From: Matthew Haley | Western Design Architects [redacted]
Sent: 15 September 2017 14:29
To: Simon Davis; 'M Haley'
Cc: 'Rianna Holliss'; Gareth Garner; Gregg Cook; kai fisher
Subject: RE: Land to the rear of 6, Ockley Road, Bogna Regis

Land to rear of No.6, Ockley Road, Bogna Regis, PO21 2HW
Application No: BR/135/13/

Planning Application – BR/239/17/NMA

With regards to the above application submitted on 18/08/2017 please find the attached drawing 02_Rev H_Site Plan, which is to replace the previous drawing 02 Rev G which was submitted with the application.

DRAWING TITLE
Proposed Site Plan & Landscape Plan

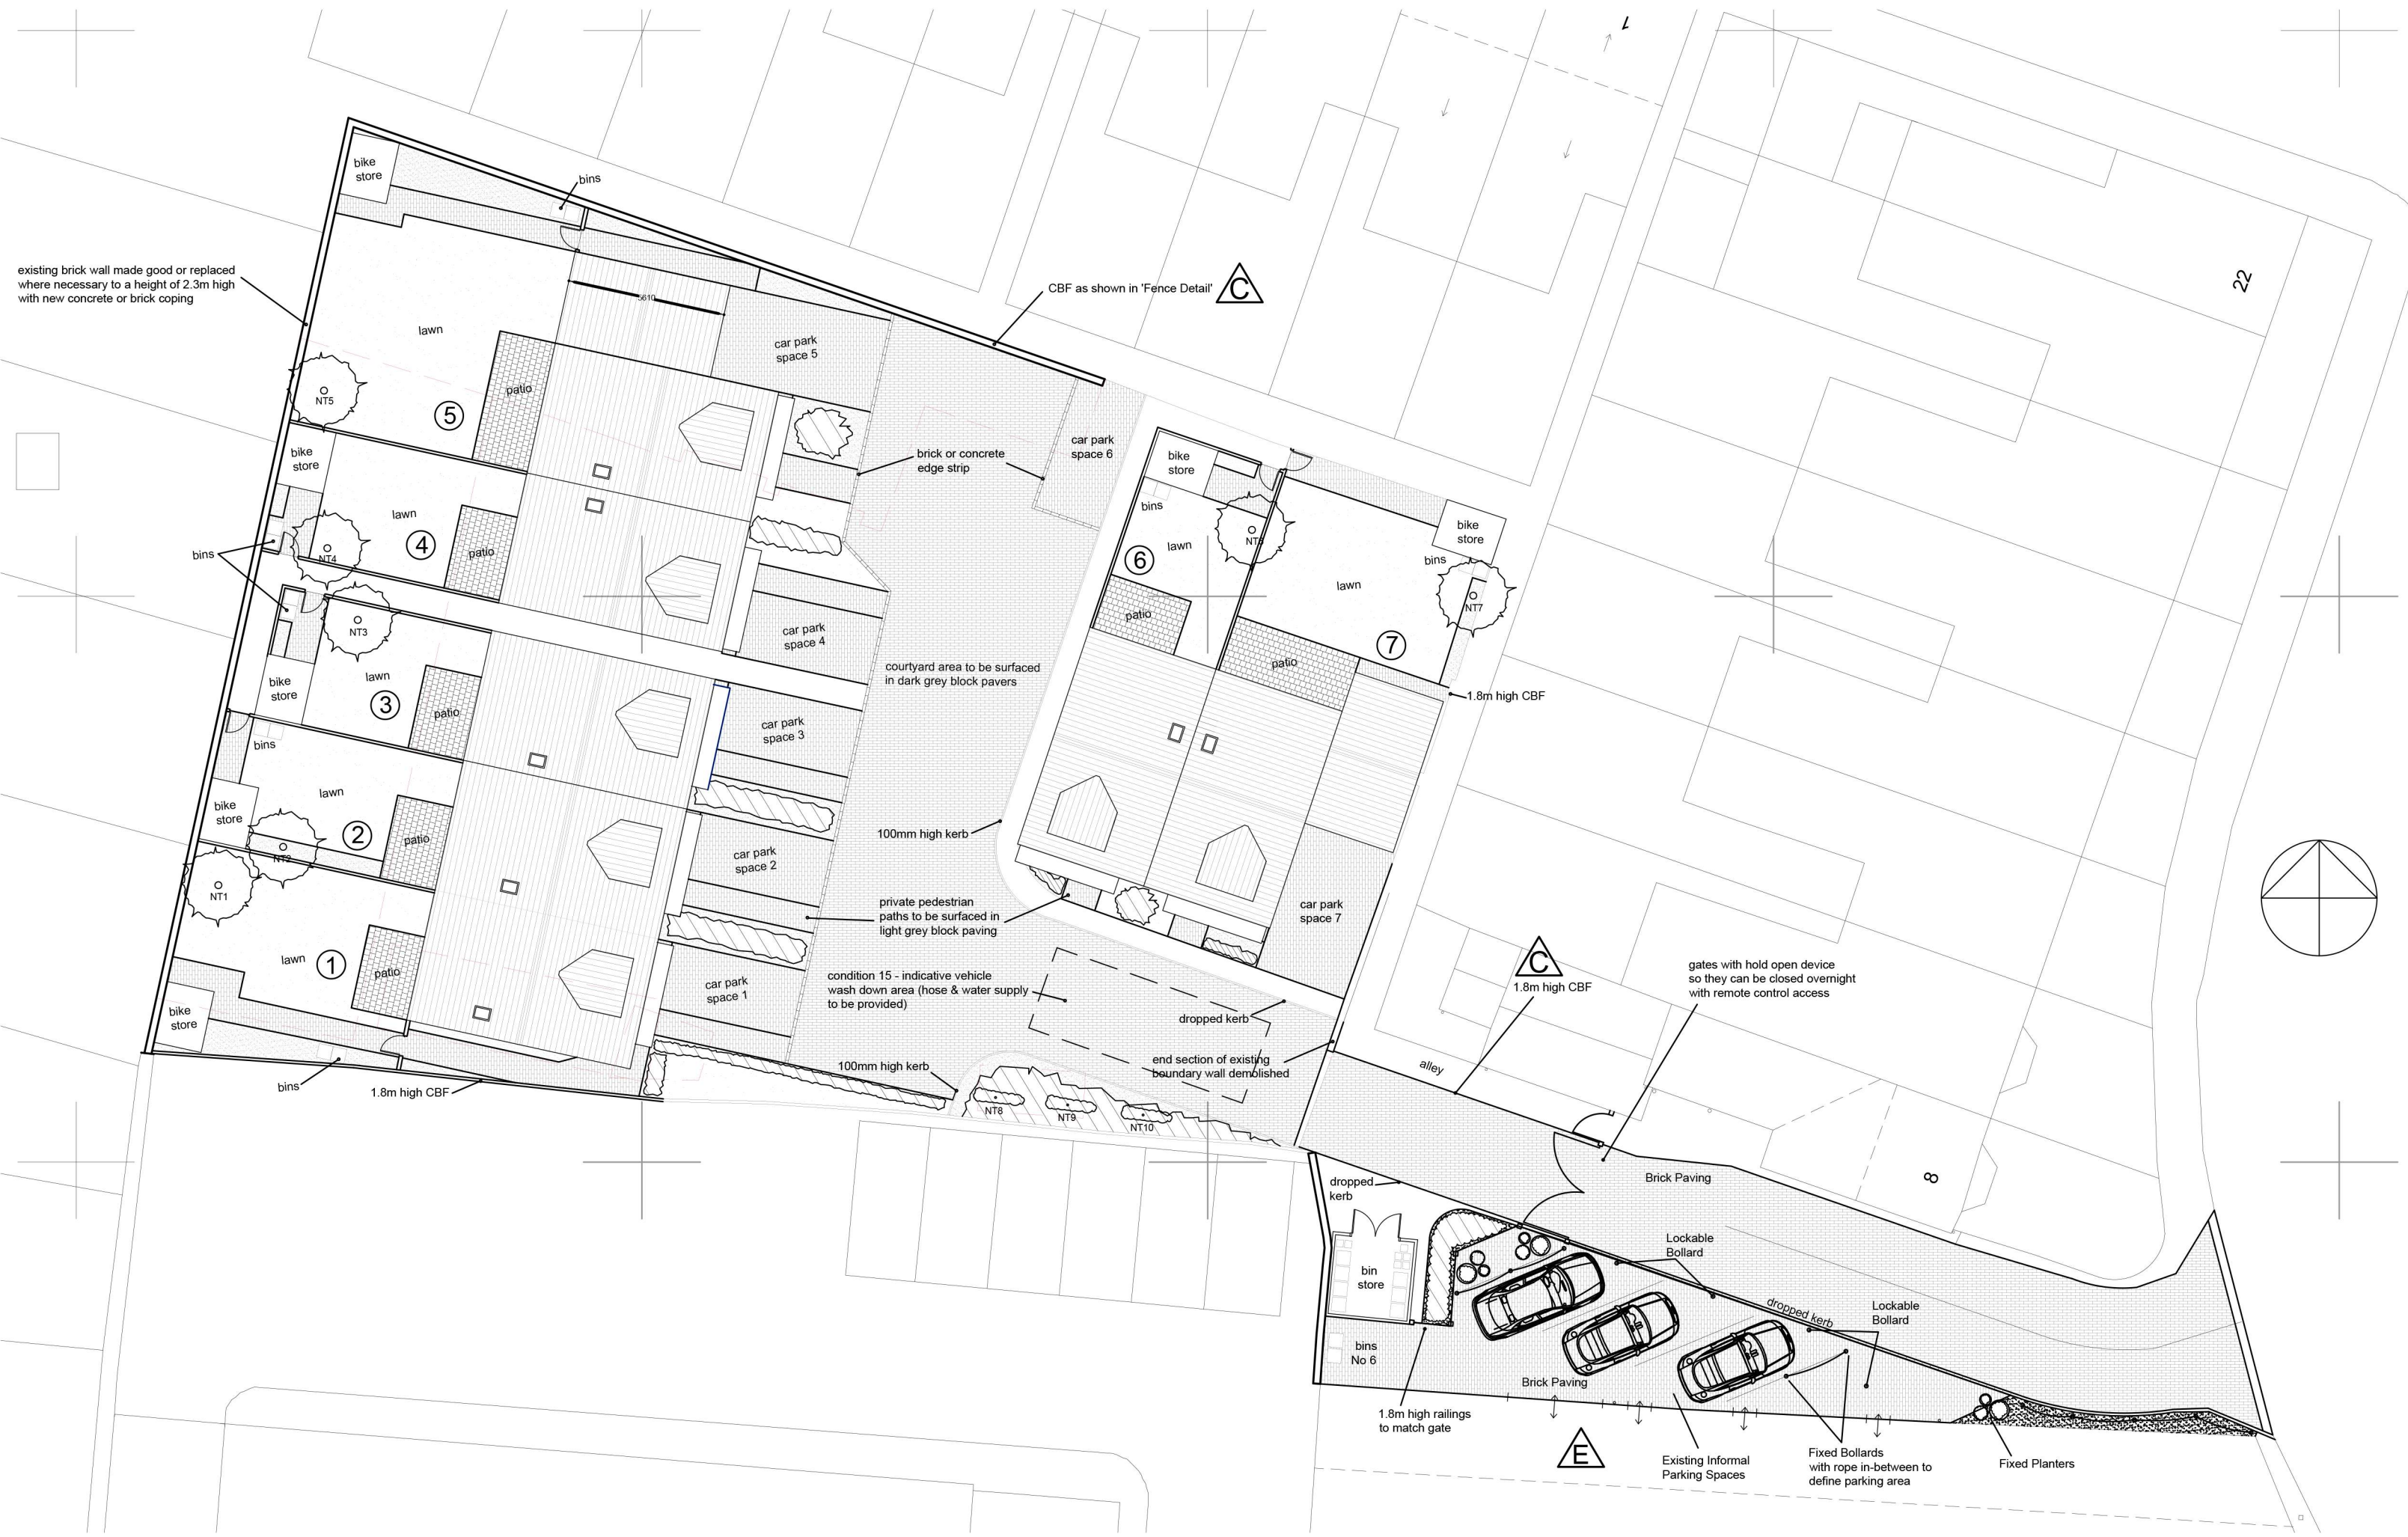
The changes to this revised drawing include the removal of the side pedestrian access gate (the pedestrians can use the main gates) and the addition of pillars either side of the electric gates to allow for more space behind the moving elements which is a safety requirement.
